June 11, 2024

**Re: Peerless Farms Preliminary Plan**  
**File #: SP217, Applicant: Robert S. and Wendy K. Williams**  
 Part of the N ½ of the NW ¼ of Section 13, Twp. 13 South, Rng. 64 West, 6<sup>th</sup> P.M.  
 Water Division 2, Water Association 10  
 Upper Black Squirrel Creek Designated Basin  
 CDWR Subdivision No. 29052 - 7<sup>th</sup> Letter

SITE PLAN EXHIBIT
SHEET 1 OF 1

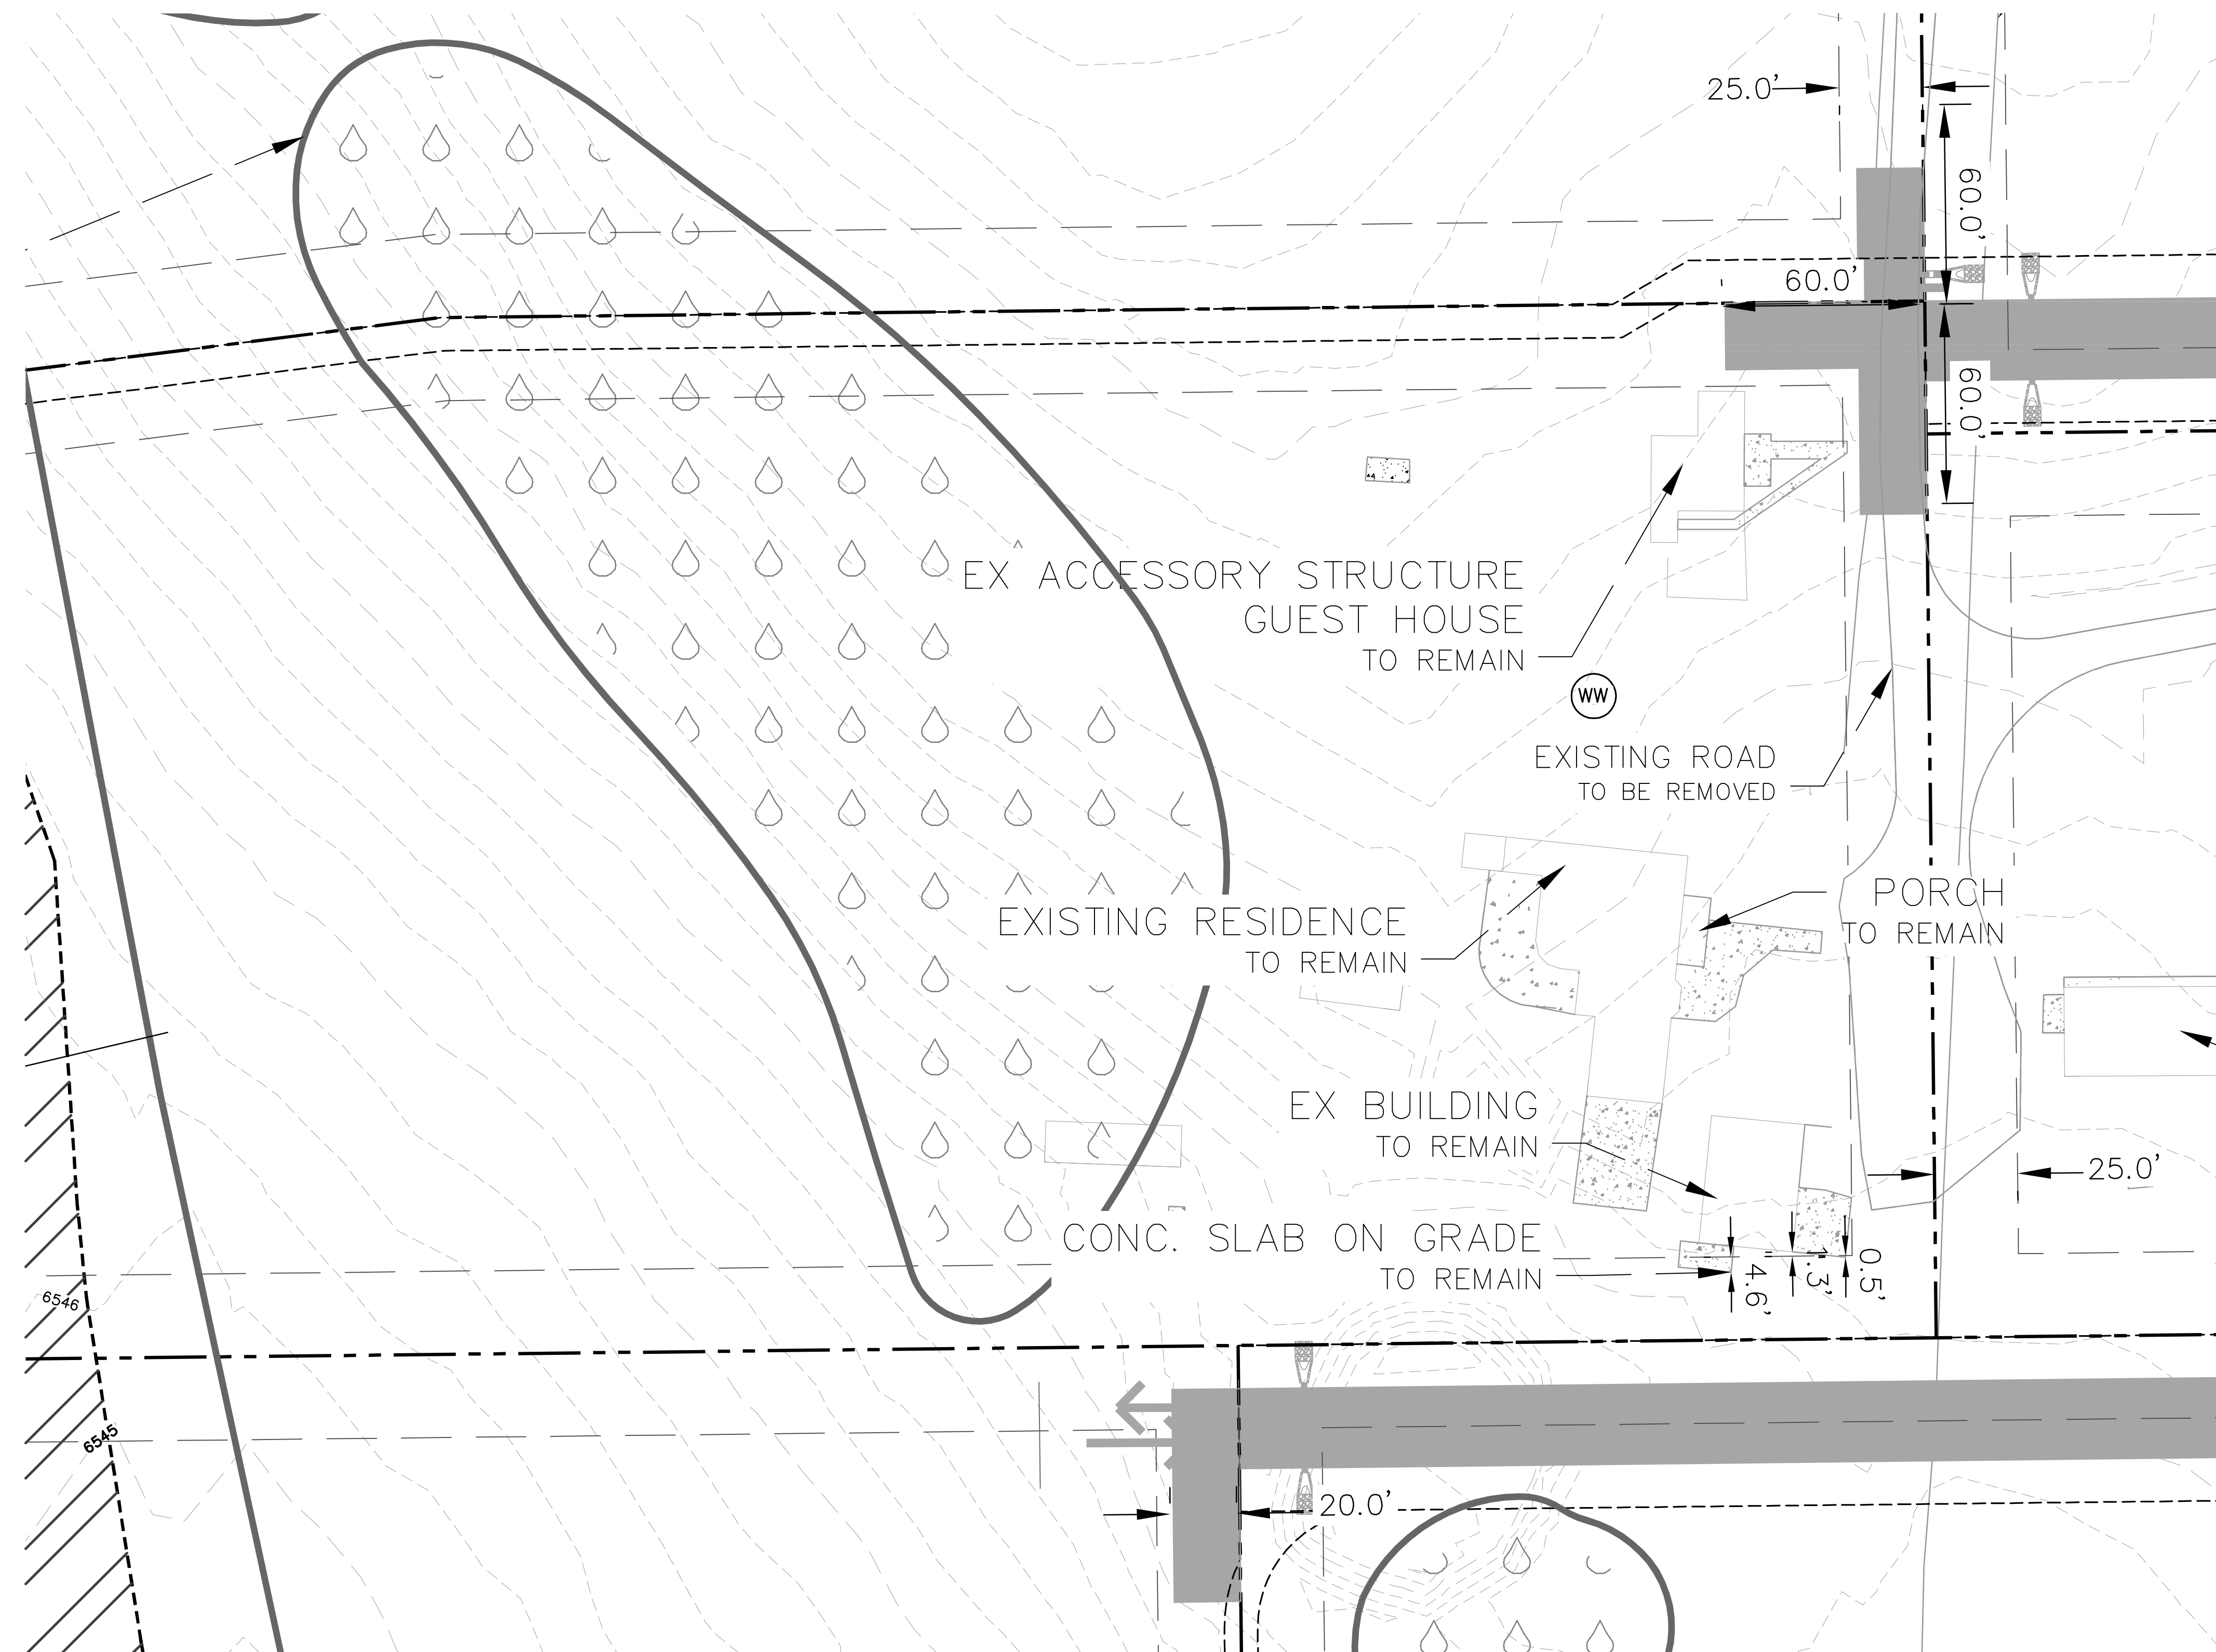
According to the submitted material, stormwater detention structure(s) will be developed on the site. The Applicant should be aware that, unless the structure can meet the requirements of a "storm water detention and infiltration facility" as defined in Designated Basin Rule 5.11, the structure may be subject to

administration by this office. The Applicant should review Rule 5.11 to determine whether the structure meets the requirements of the Rule and ensure any notification requirement is met.
